Re: MHP/AOC Respite Care Addition, 715 Candelaria Rd. NE,
 Traffic Circulation Layout

**Re: MHP/AOC Respite Care Addition, 715 Candelaria Rd. NE,
Traffic Circulation Layout
Architect's Stamp Not Dated (G15—D001)**

**Re: MHP/AOC Respite Care Addition, 715 Candelaria Rd.NE,
Traffic Circulation Layout
Architect's Stamp Not Dated (G15—D001)**

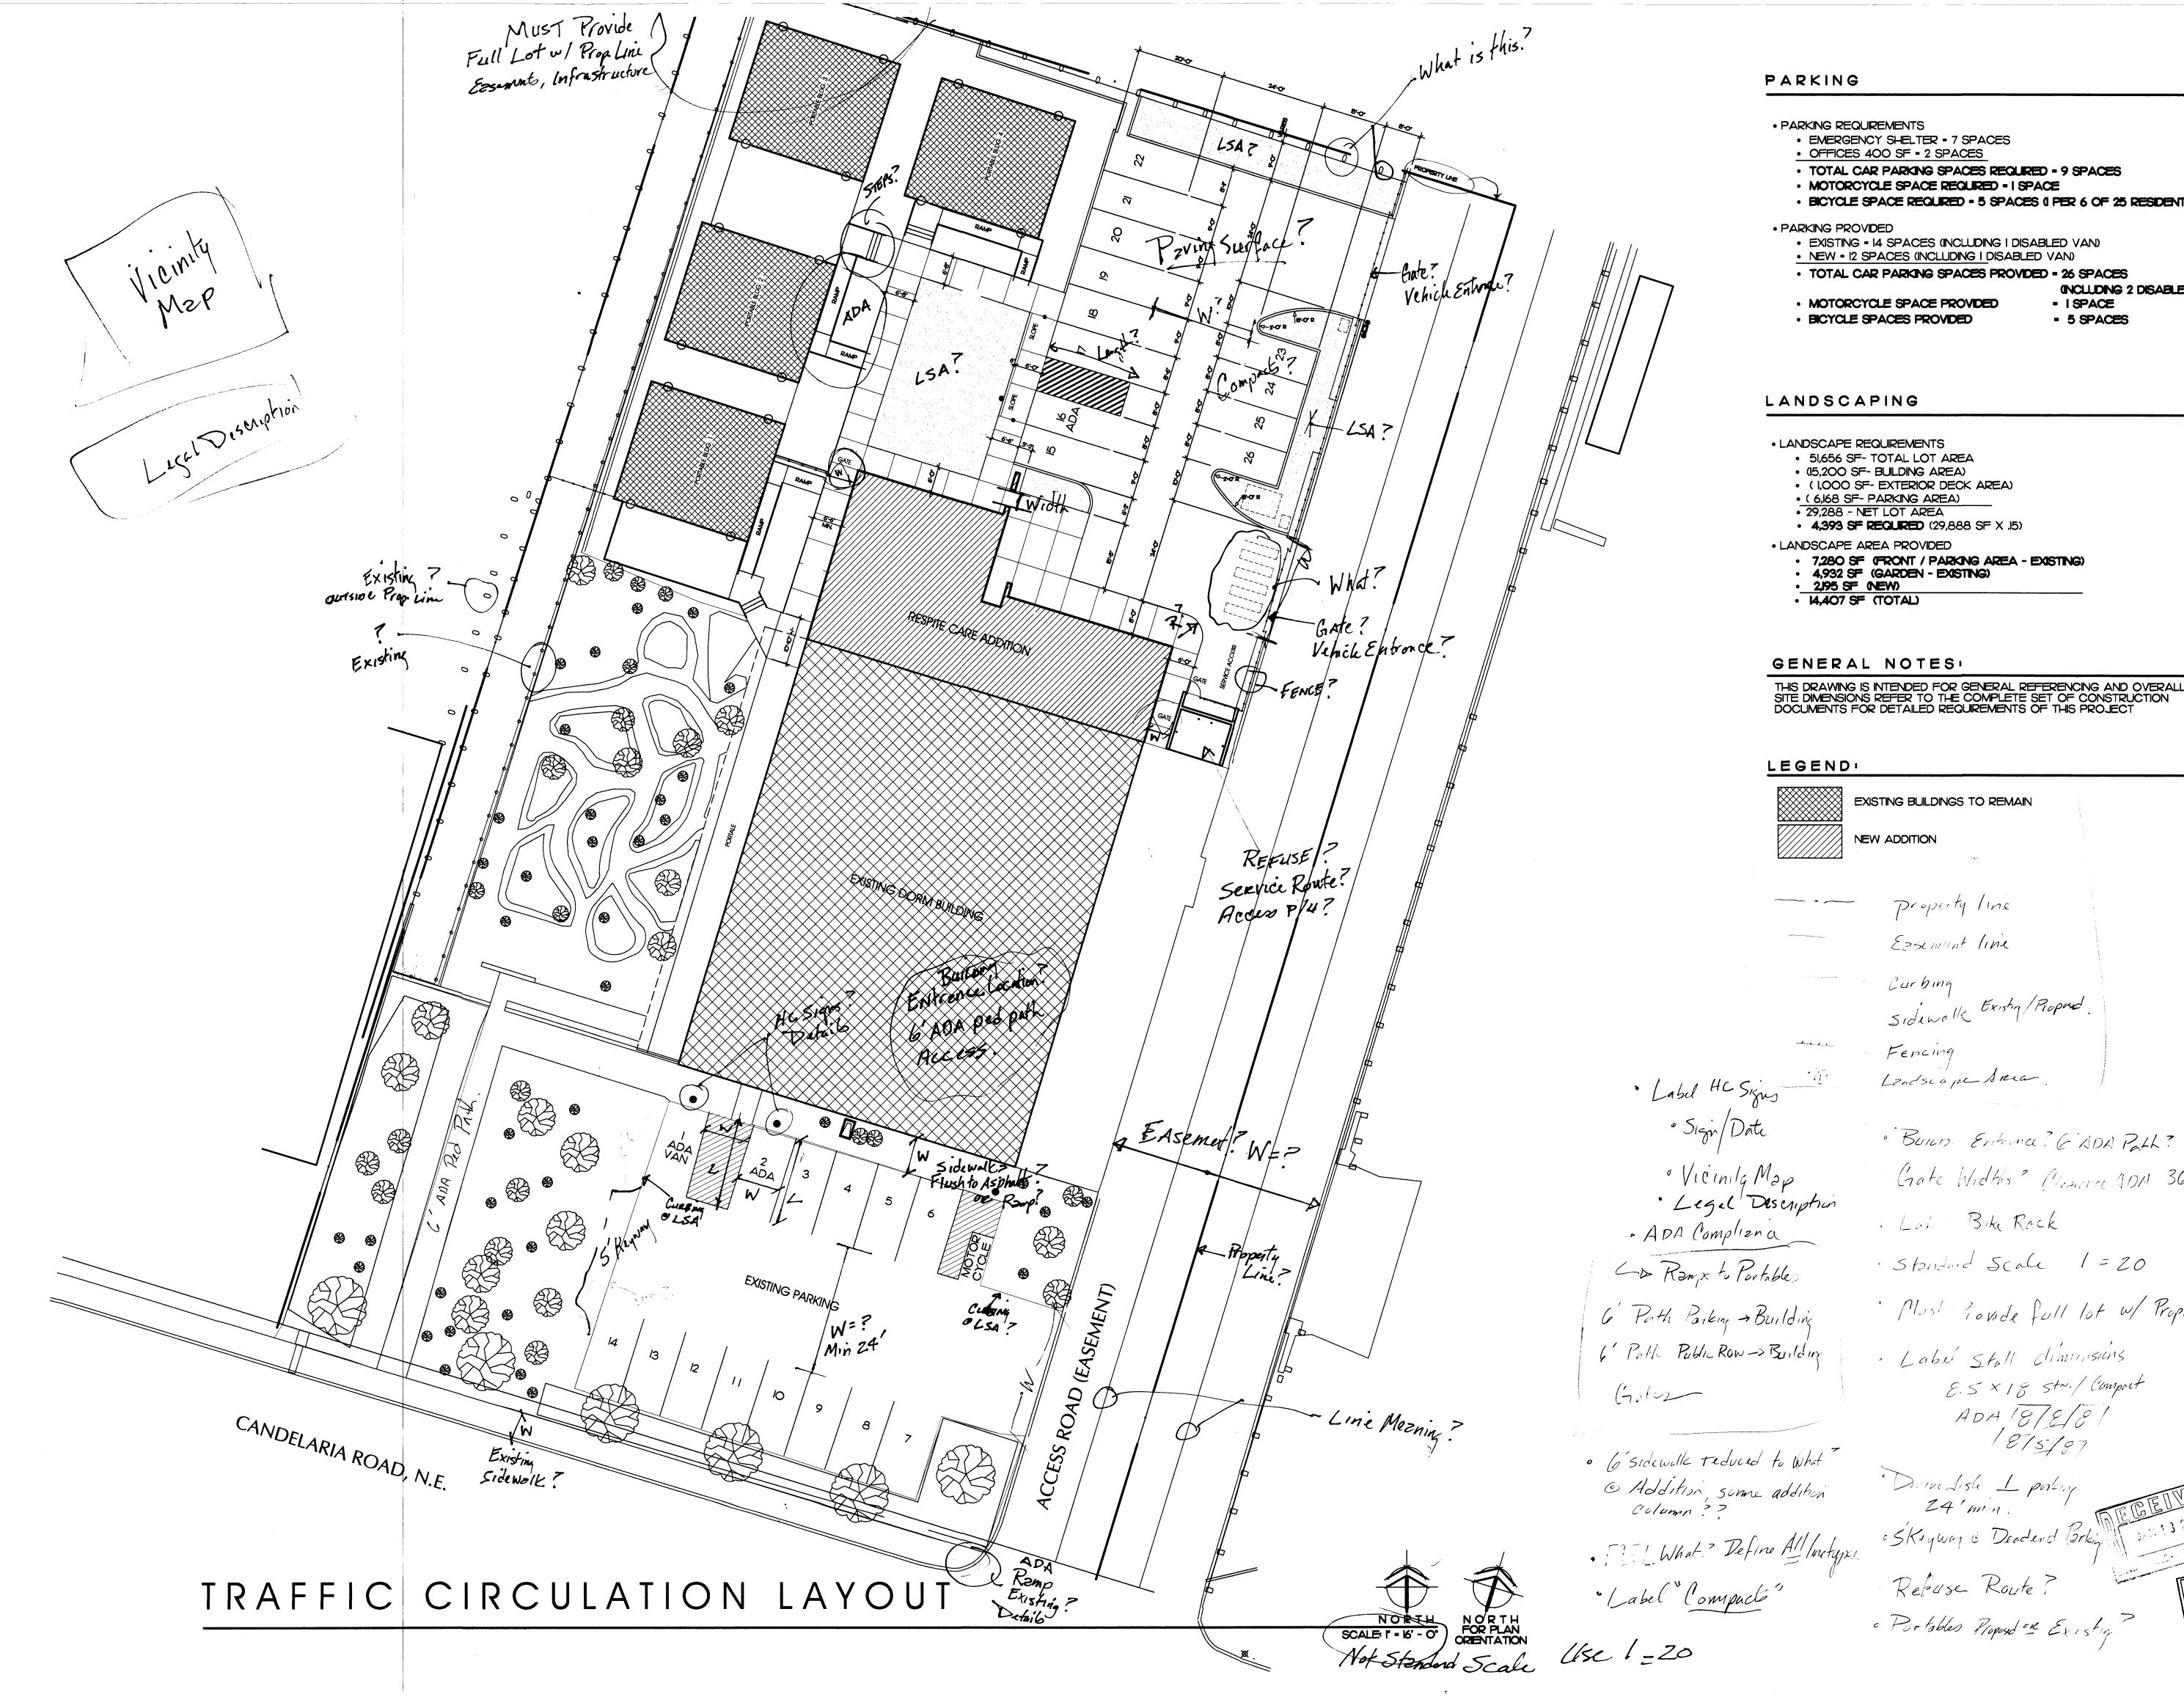
1. Please ensure all ramps are ADA compliant.
2. Please provide a six foot, concrete, ADA accessible, pedestrian walkways from street sidewalk to the principal customer entrance of the nearest building on site.*

3. The concrete landing abutting customer entrance does not appear to be ADA compliant. Please refer to current *2010 ADA Standards for Accessible Design*, Ch. 4, section 404, for maneuvering clearances at manual swinging doors.

4. The vehicular pavement markings for the parking lot circulation show one-way circulation. One-way parking and circulation have specific *Development Process Manual (DPM)* requirements, angled parking stalls and narrow drive aisle widths, to ensure intended circulation movement. The proposed perpendicular parking stall layout with 24 foot drive aisle conforms to a two-way layout. Please design parking lot to conform to DPM standards Chapter 23, figure 23.7.1.

5. Please provide details for the proposed security fence and gates adjacent to the drive aisles at the proposed parking area. Refer to *DPM* Chapter 23; section 6.12 "*Visibility for Driveways.*" Please demonstrate that the minimum 11 foot clear sight triangle is maintained between the vertical heights of 3 to 8 feet.

*The TCL site plan references an "Existing 6' ADA Pedestrian Path" connecting the public ROW fronting Candelaria to the buildings entrance. The crusher-fine path does not qualify as ADA accessible in this situation because it is located in an urban area, with the high traffic volume potential and the path can not ensure a "firm, stable, and slip resistance surface" during and following inclement weather. According to the IEBC, section #605.1, the building addition proposed will require the existing site to comply with current ADA standards. The exception would be to provide proof that the cost to comply would be greater than 20 percent of the entire cost of the addition.

1. All ramps are ADA compliant. Portable Building ramps were installed under a recent project permitted by the City of Albuquerque which received Certificates of Occupancy in December of 2012.

2. A six foot, asphalt, ADA accessible, pedestrian walkway from the street sidewalk at Candelaria Road to the entrance of the existing building has been provided.

3. The concrete landing at the existing building entry door abuts the new asphalt, ADA accessible pedestrian walkway and complies with *2010 ADA Standards for Accessible Design*, Chapter 4, Section 404, for maneuvering clearances at manual swinging doors.

4. The parking lot layout is designed to conform to a two-way layout per the City of Albuquerque *DPM* standards Chapter 23, figure 23.7.1.
5. Details for the proposed security fence and gates are included in this submittal (please see drawing sheet C-502 dated 19, November 2012). The minimum 11 foot clear site triangle is maintained from the edge of the access easement and per the City of Albuquerque *DPM* Chapter 23 Section 6.12 "*Visibility for Driveways.*" Please note that the access easement ends at the north property line of 715 Candelaria Road NE, and is secured by a fence and electric gate.
